REPORT on the IMPLICATIONS for EUROPEAN SITES

Proposed Thurrock Flexible Generation Plant

Planning Inspectorate Reference: EN010092

19 July 2021

Figure 4.2: Accumulated depth over a 3-year period for SSC of 250 mg/l, bulk (wet) density of 1500 kg/m³; and SSC of 500 mg/l, bulk (wet) density of 1300 kg/m³.

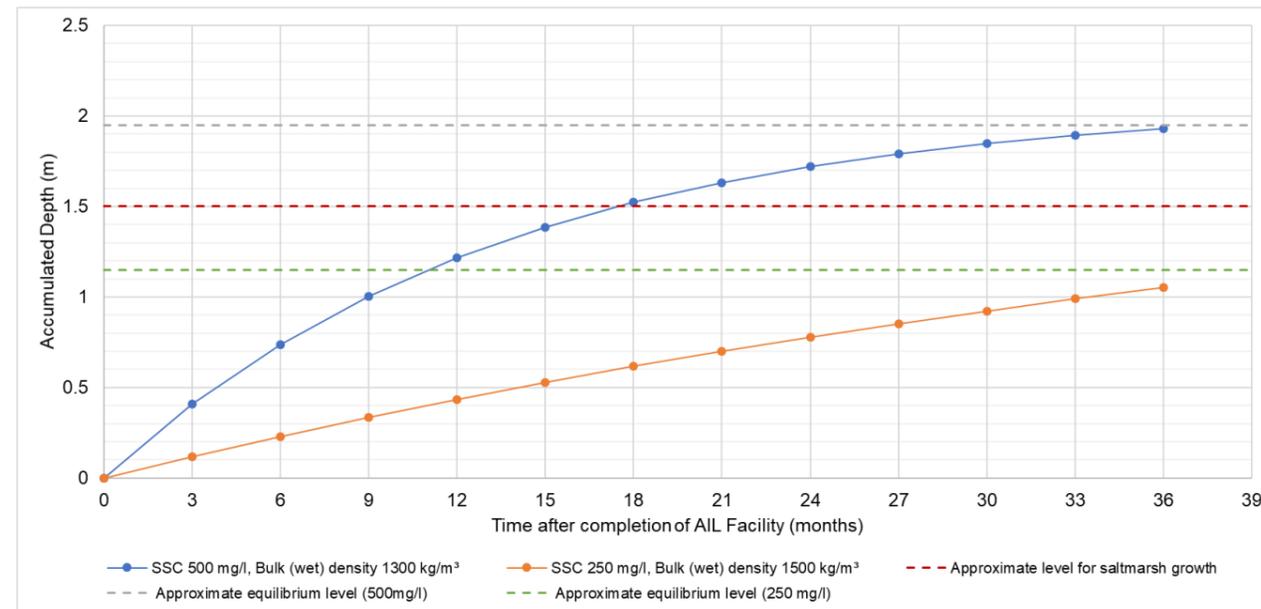
- 3.4.3 The Applicant submitted an updated HRA Report [**REP2-022**] to acknowledge this area as FLL (paragraphs 5.1.6 to 5.1.20). The HRA Report screened out direct loss of habitats as an impact pathway for the Thames Estuary and Marshes sites features in paragraph 5.1.20 on the basis that the mudflat is located outside of the SPA and is only a small proportion of the available habitat resource in the context of the SPA/Ramsar site (1.5% temporary loss of FLL during construction and 0.37% long-term loss during operation over 35 years). It considers that losses of mudflat from sediment accretion would be reversed once the causeway is decommissioned.

- 3.4.4 NE [**PDD-012**] does not agree this impact should be screened out of the assessment and argues that this has potential to undermine the objective to maintain and restore '*The extent and distribution of the habitats of the qualifying features*' as the Proposed Development does not provide

- 3.4.9 The Applicant [**AS-048**] in support of the HRA [**REP2-022**] screening assessment undertook a further assessment to demonstrate that direct habitat loss as a result of the causeway is <1% of the available mudflat resource both for the whole SPA/Ramsar sites and at a local scale (in the context of Mucking Flats SSSI only) and therefore no likely to cause a significant effect on SPA/Ramsar features. A response is awaited from NE on this document.

Figure 1.1 Proposed causeway structure.

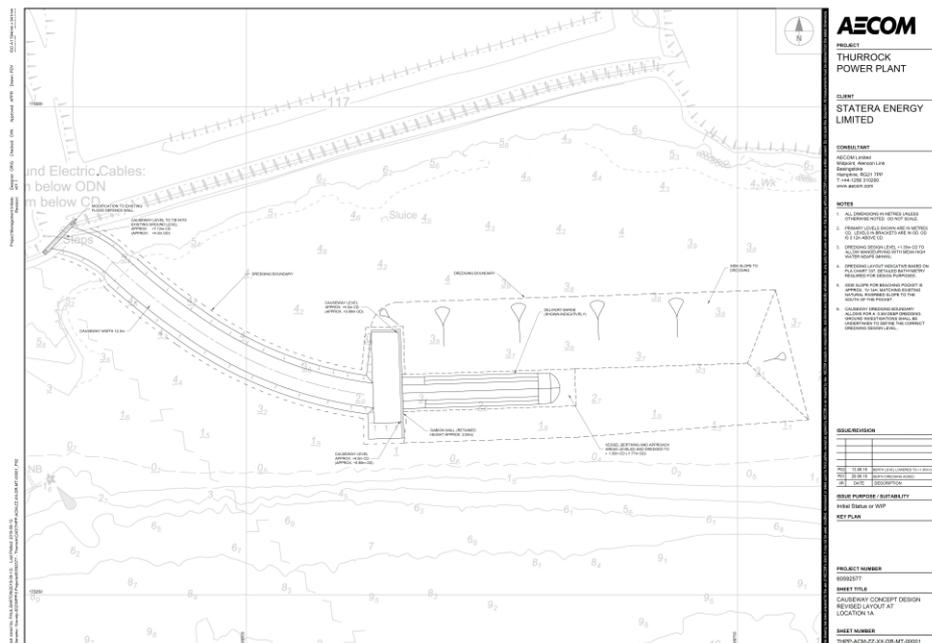
- 3.4.2 NE [**RR-022**] disputed screening out this impact as the assessment of impacts to FLL had only been undertaken for onshore habitats whereas it considered that the intertidal area between Coalhouse Fort and Tilbury Fort where the proposed causeway is located (Zone G) is also FLL. NE highlighted that the Applicant's Foreshore Wintering Birds Surveys (2019-2020) [**APP-094**] recorded Dunlin, Redshank and Ringed Plover features, and in particular, high numbers of Avocets, within the causeway area (Zone G) between November and March and therefore, the conclusion that these features are not present on FLL is not supported. NE anticipate that habitat loss would arise due to direct loss of mudflats from the causeway structure and from accretion influenced by the causeway [**RR-022**].
